Engineers Comments Regarding Surface Water Drainage

Application Reference:	AL/54/24/DOC	Reviewer Reference:	ADC/EXT2/D2134/100
Planning Officer:	David Easton	Date of Review:	08.06.2026
Site Name:	Nyton Nursery Nyton Road Westergate PO20 3UQ		
Application Description:	Approval of details reserved by condition imposed under reference AL/3/19/PL relating to conditions 18- as-built drawings of surface water drainage scheme, 19 - surface water drainage scheme, 20 - works to watercourses and 21 - maintenance and management of surface water drainage scheme.		
Assessment Number:	1 of 2

TYPICAL SECTION THROUGH POS HOGGIN FOOTPATH
Scale 1:20

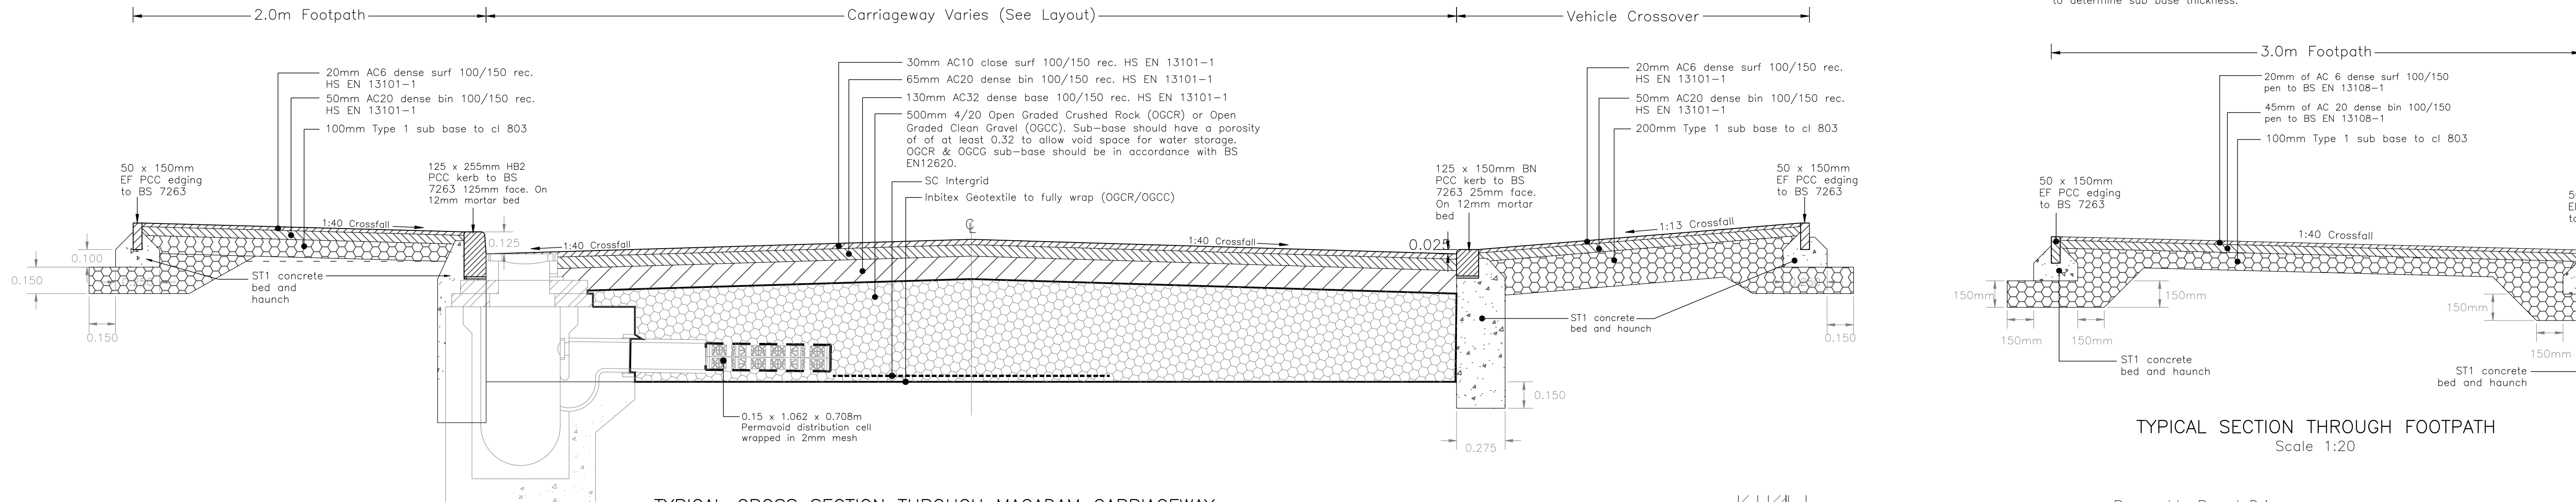
The same can be seen from numerous permeable pavements levels which must only focus on the sub-base storage layer. Please revised all calculations to show the correct depths otherwise the 'status' and water level observed is being wholly falsified. Whilst the depth will be corrected this is misleading and does not correctly report situations when the sub-base is at risk or has breached ground level.	file to match the exact levels. We hope this explanation is satisfactory. We have provided some examples in the folder Comment 22. Please see updated calculations.

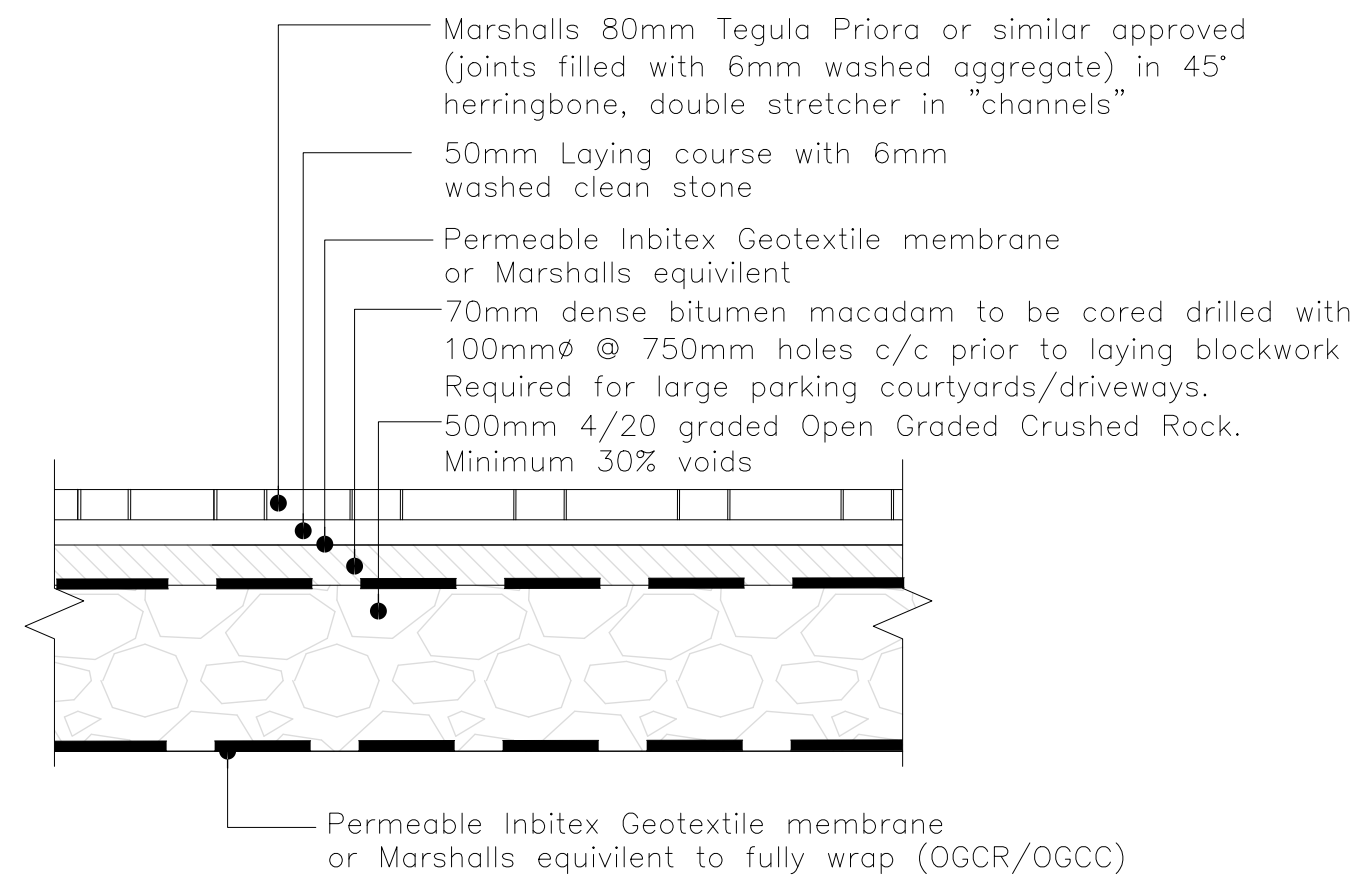
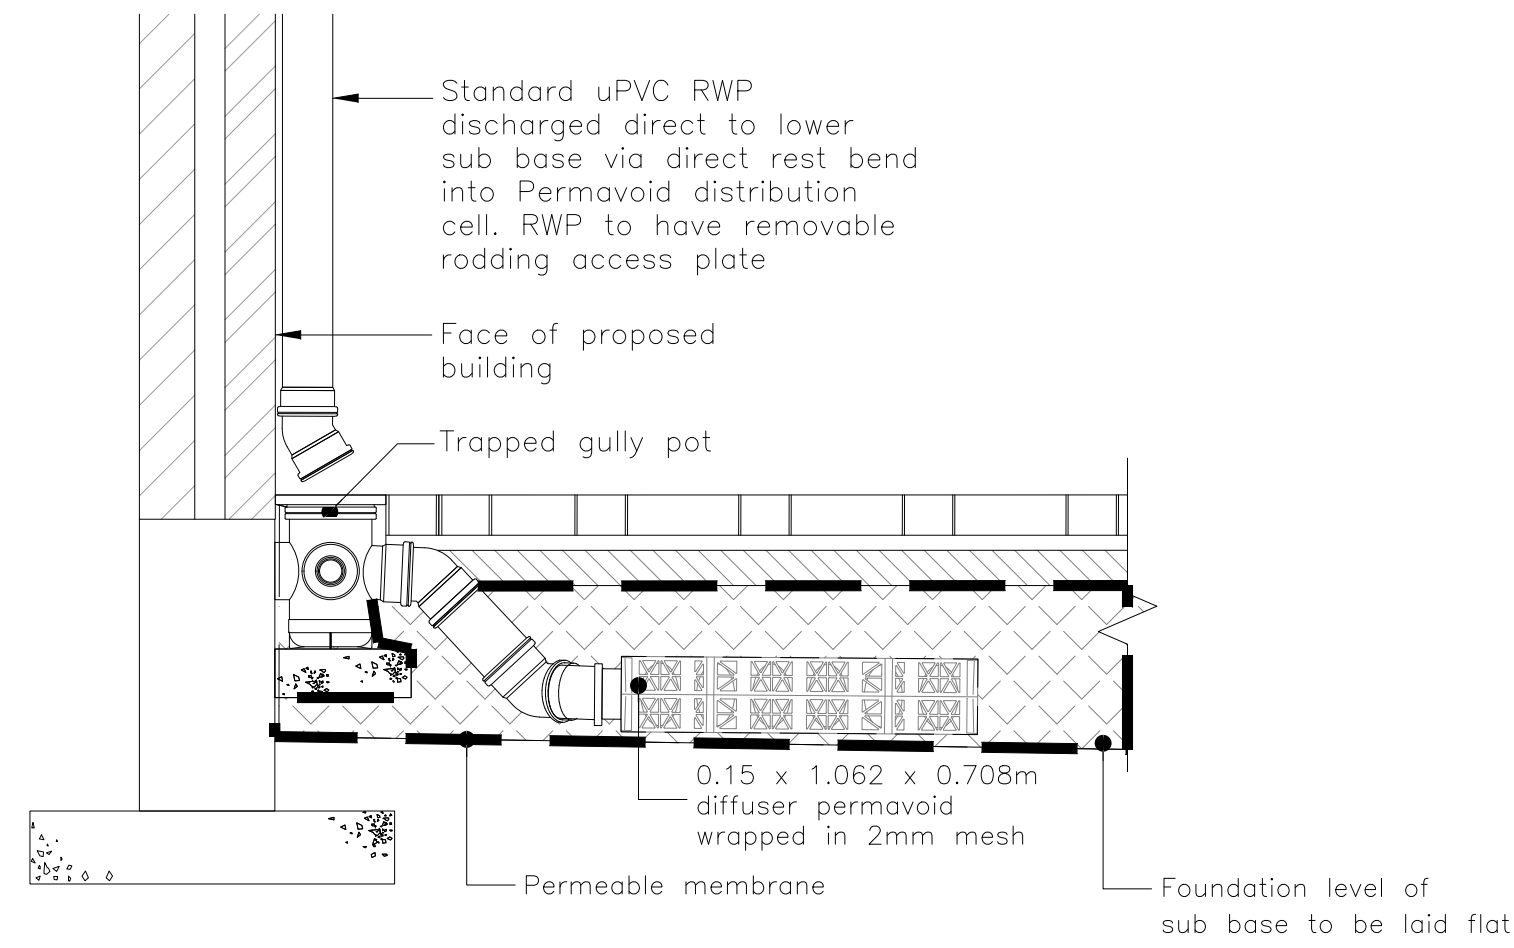
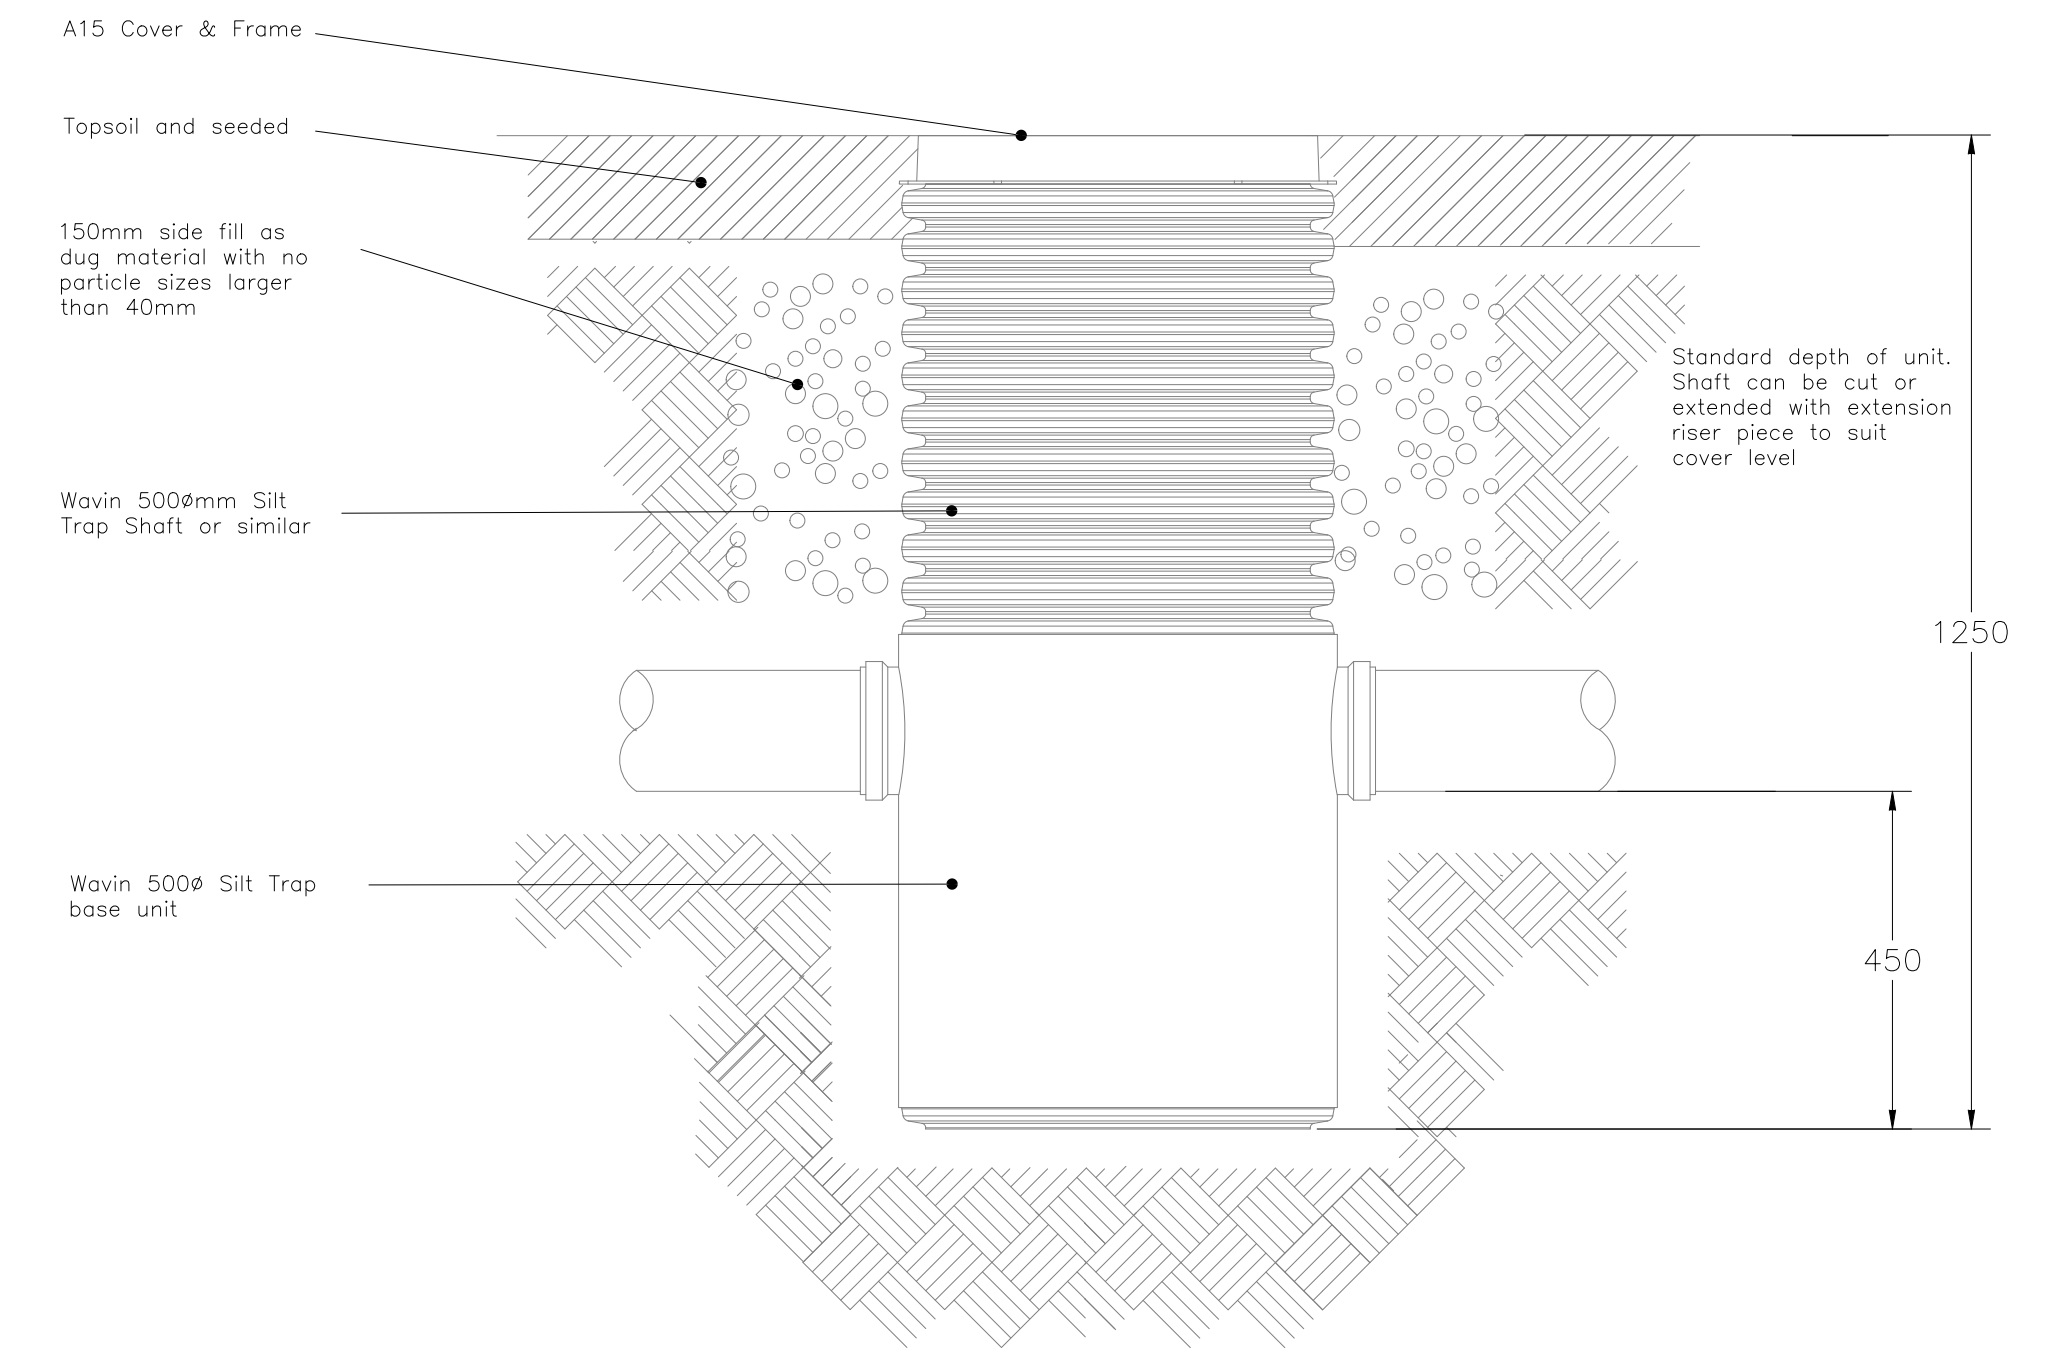
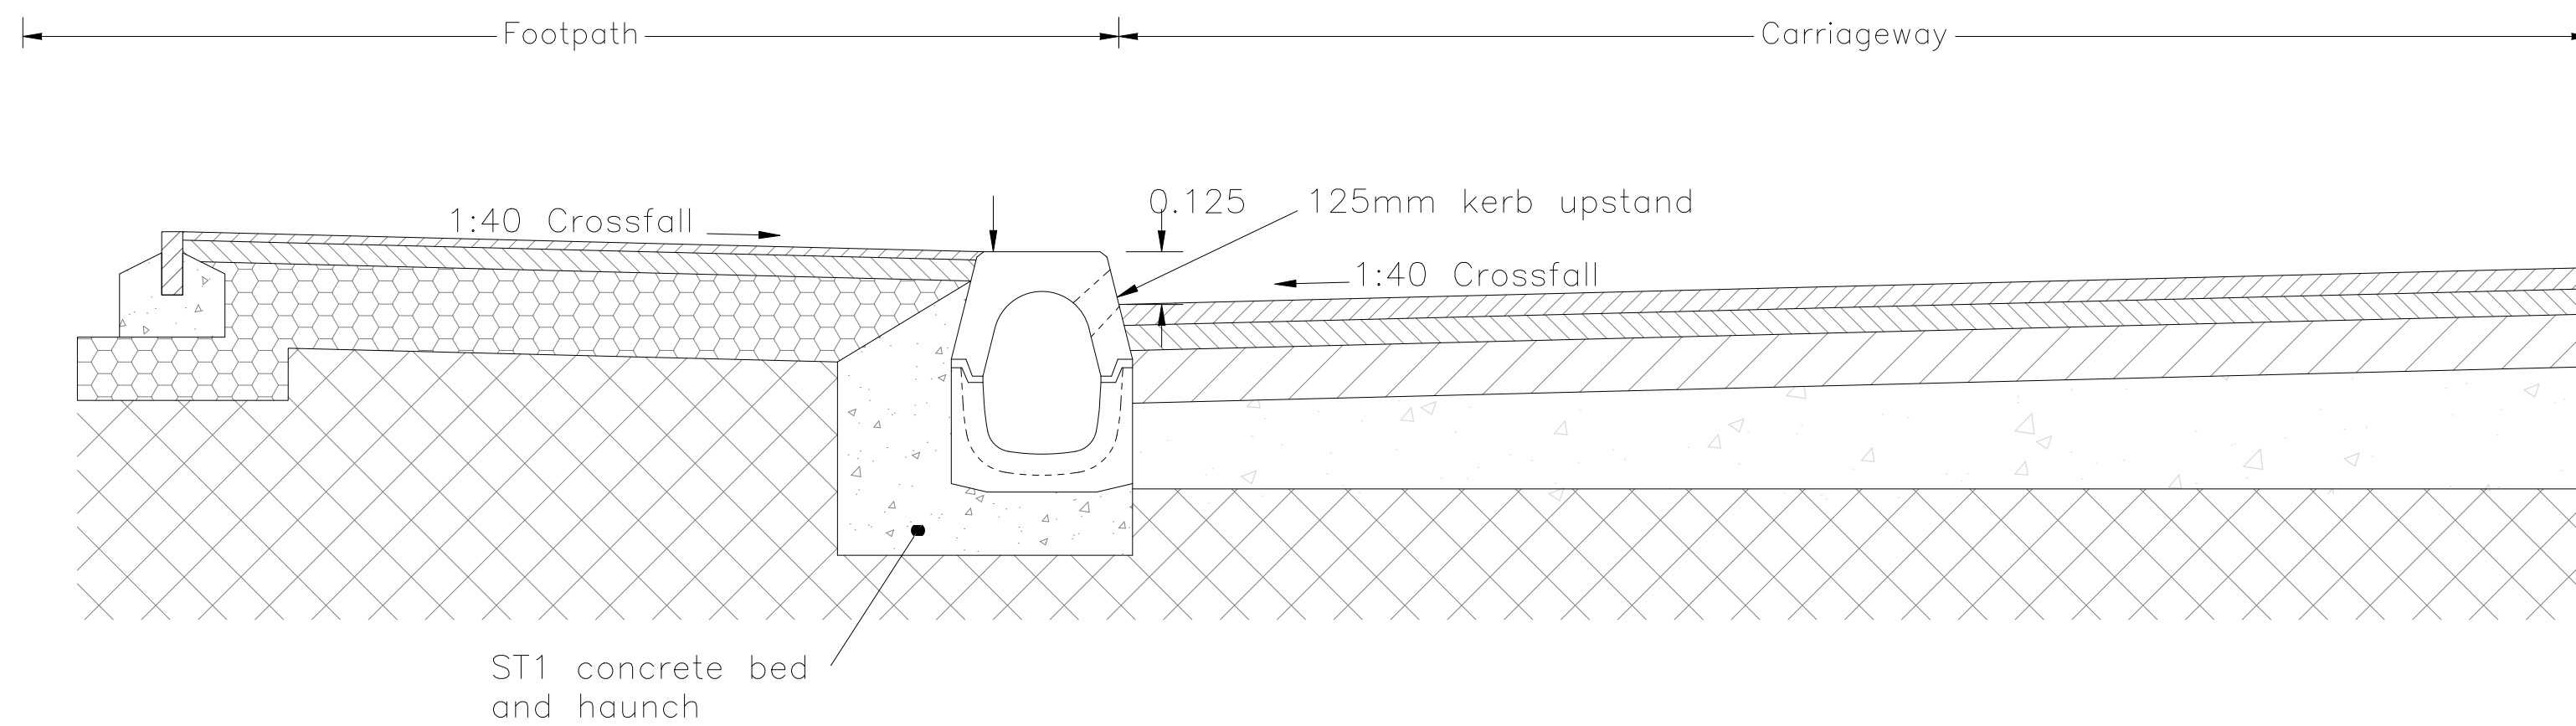
6.	ADC 28/04/2023: Please confirm how silt will be collected and removed where rainwater pipes are shown to connect directly to permeable paving sub base. Eg. Plot 122, 125, 126 etc. Designer response 14/12/2023: Silt will be collected via a trapped gully pot. See drawing '5655-22_A Sewer Details' ADC 21/02/2024: This needs to be discussed at detail in the management & maintenance report. Routine gully maintenance dictates gullies will be pressure cleaned which will result in some silt/debris being washed down into the sub-base where no control catchpits can be used to mitigate this. Eventually the sub-base will become clogged resulting in a significant loss of storage and conveyance. Sub-base replacement must be considered. Furthermore this does not comply with CIRIA treatment	Paragraph 4.19 of the SuDS M&M plan details sub-base replacement frequency. The EA have not been consulted. Roof water being discharge to formation level carries minimal contamination risk and the lowest mitigation indices. Gully socks will be added to road gullies.	Noted. Noted, please ensure gully socks, sponges or other equivalent products are installed. Comment closed.
